From: Cornelis Duba [<mailto:Cornelis.Duba@endeavourenergy.com.au>]
Sent: Thursday, 9 August 2018 1:18 PM
To: DPE CSE Information Planning Mailbox
Cc: Simon Lawton ; Steven Baker
Subject: NSW Department of Planning and Environment Notice of Exhibition Tallawong Station Precinct South (SSD 9063)

I refer to the Department's letter of 10 July 2018 regarding Concept State Significant Development Application (SSD) for the Tallawong Station Precinct South, located at 69-79 Schofields Road, Rouse Hill in the Blacktown Local Government Area (Lots 13, 14 & 15 DP 1168129, Lot 10 DP 1185116) for a mixed-use precinct located south of the approved Tallawong Station comprising:

SITE ANALYSIS

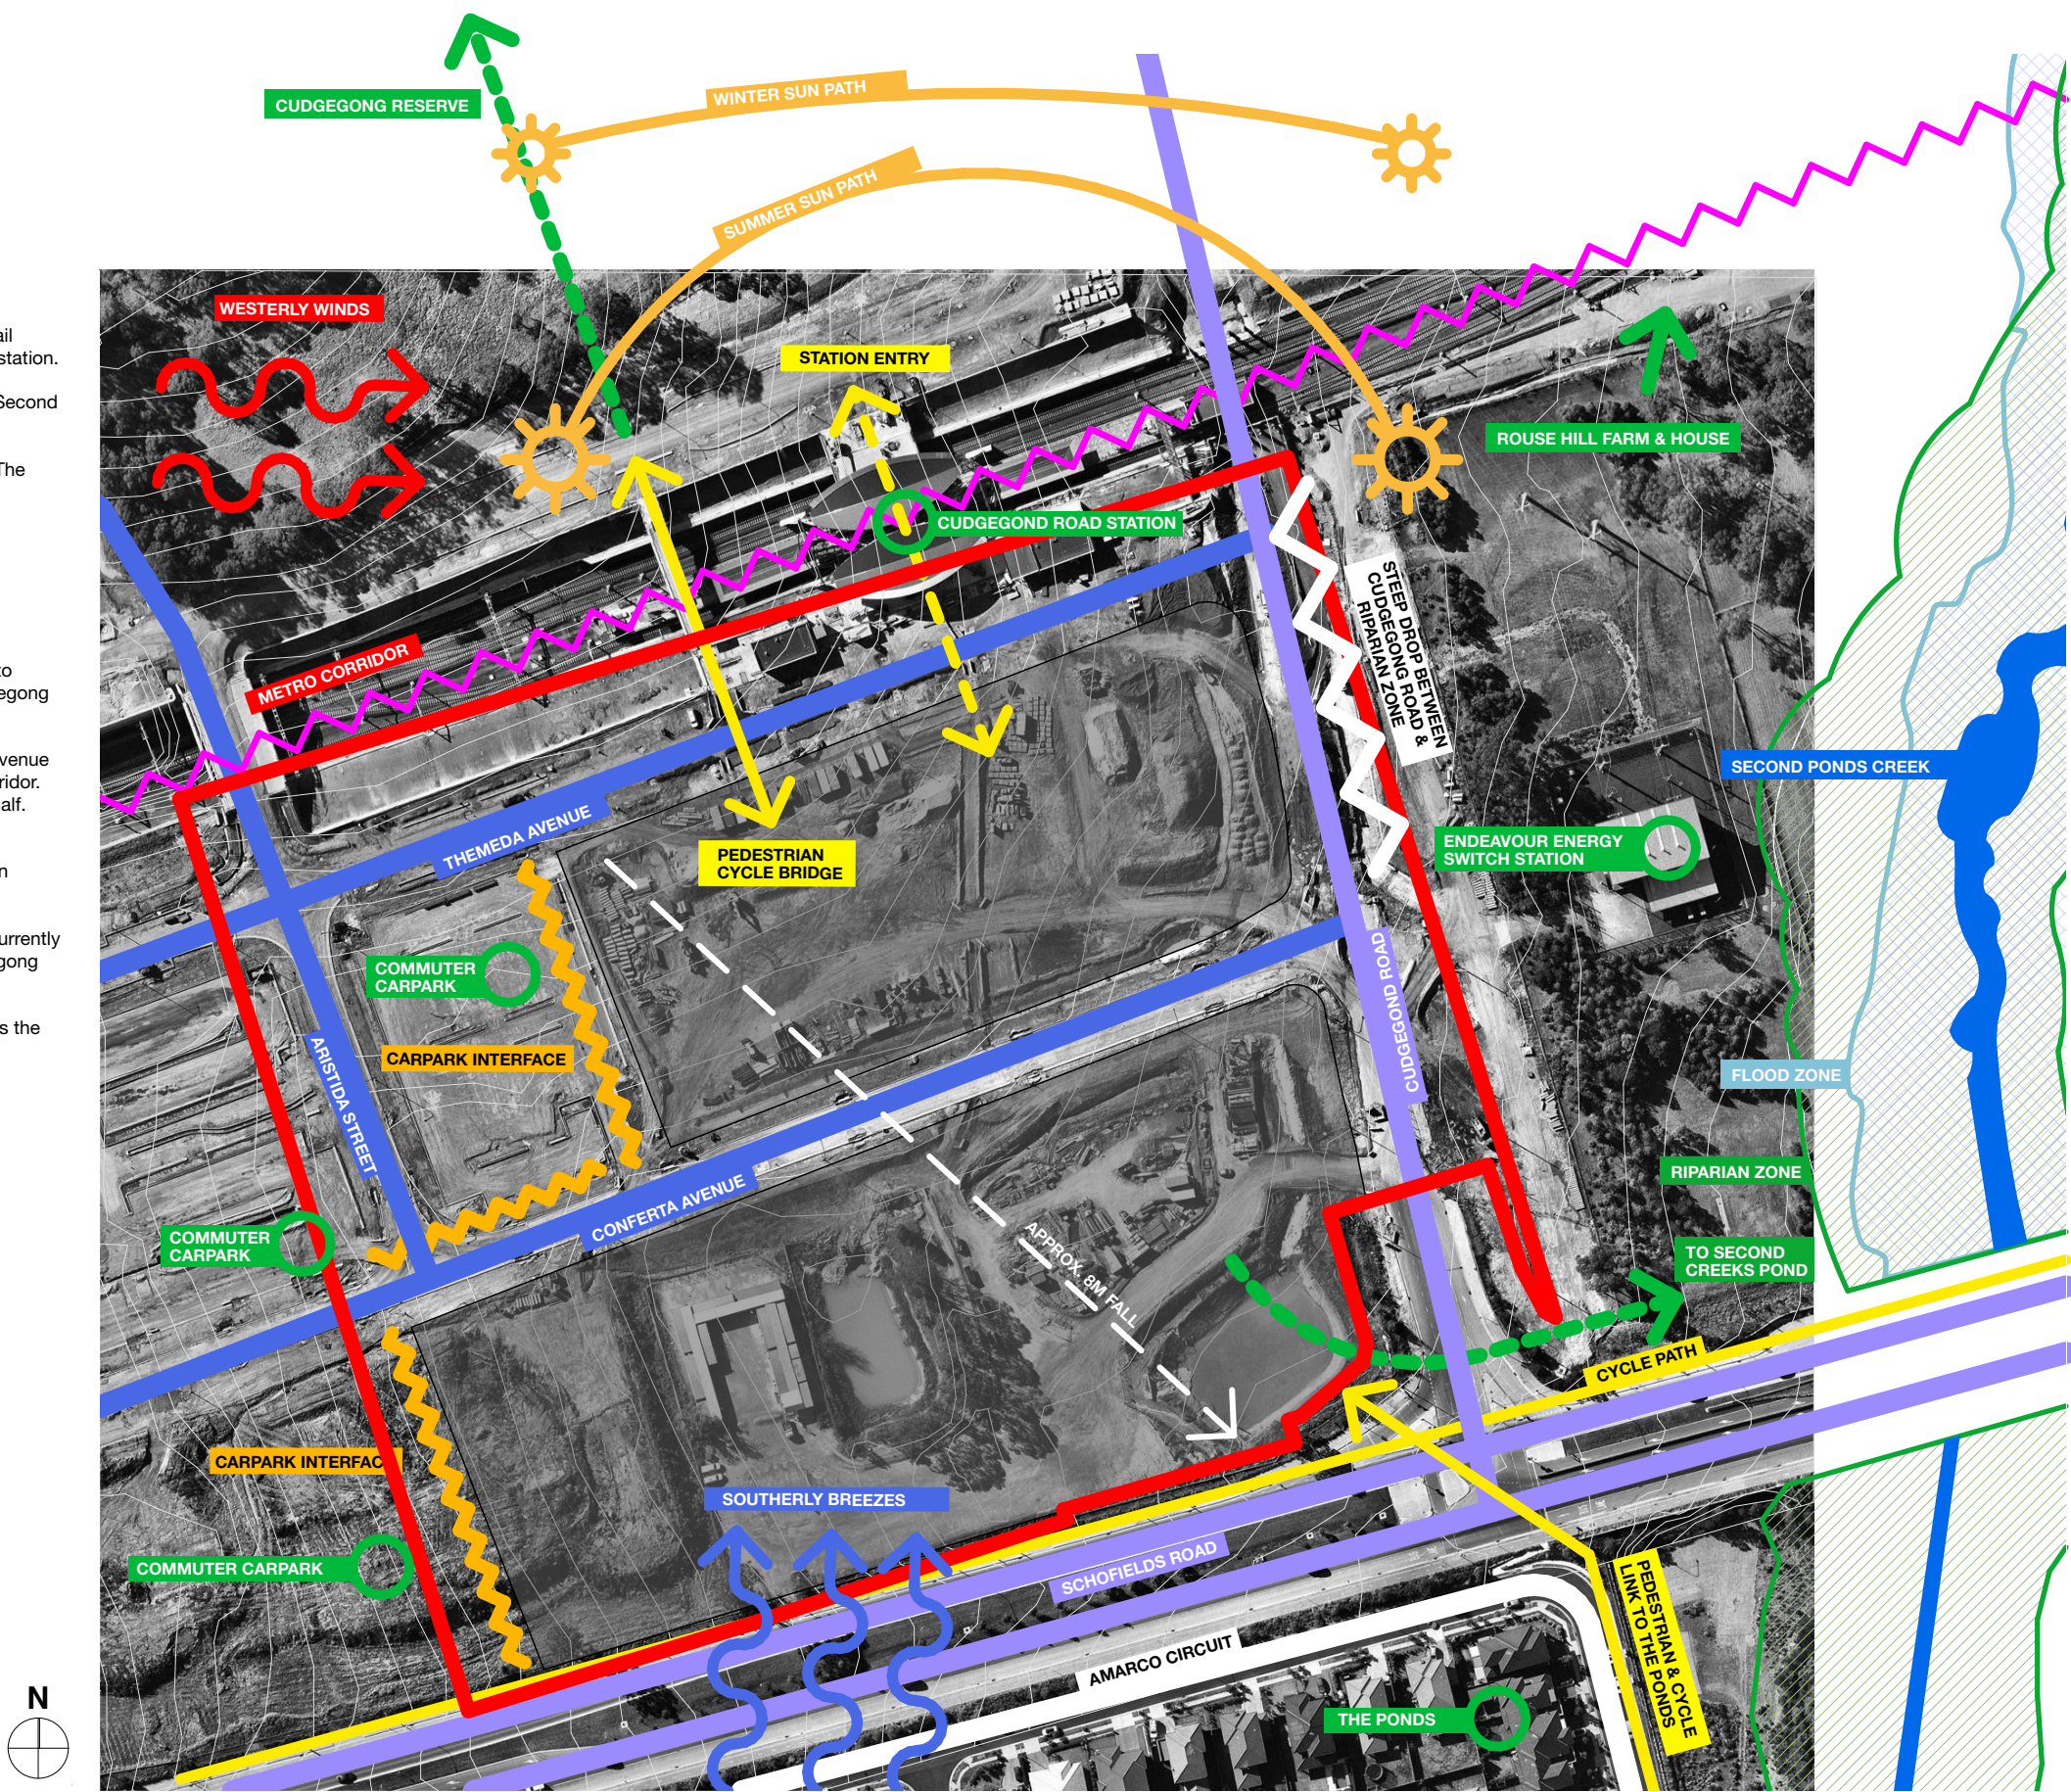
Endeavour Energy has noted that the Environmental Impact Statement does not appear to mention the proximity to Rouse Hill Switching Station or Feeder 9JA. The Urban Design Report as shown in the following extract of the Site Analysis Plan shows 'Endeavour Energy Switch Station' but there appears to be no detail / discussion about a 'complimentary interface' between the Rouse Hill Switching Station / Feeder 9JA and the buildings to the opposite side of Cudgegong Road.
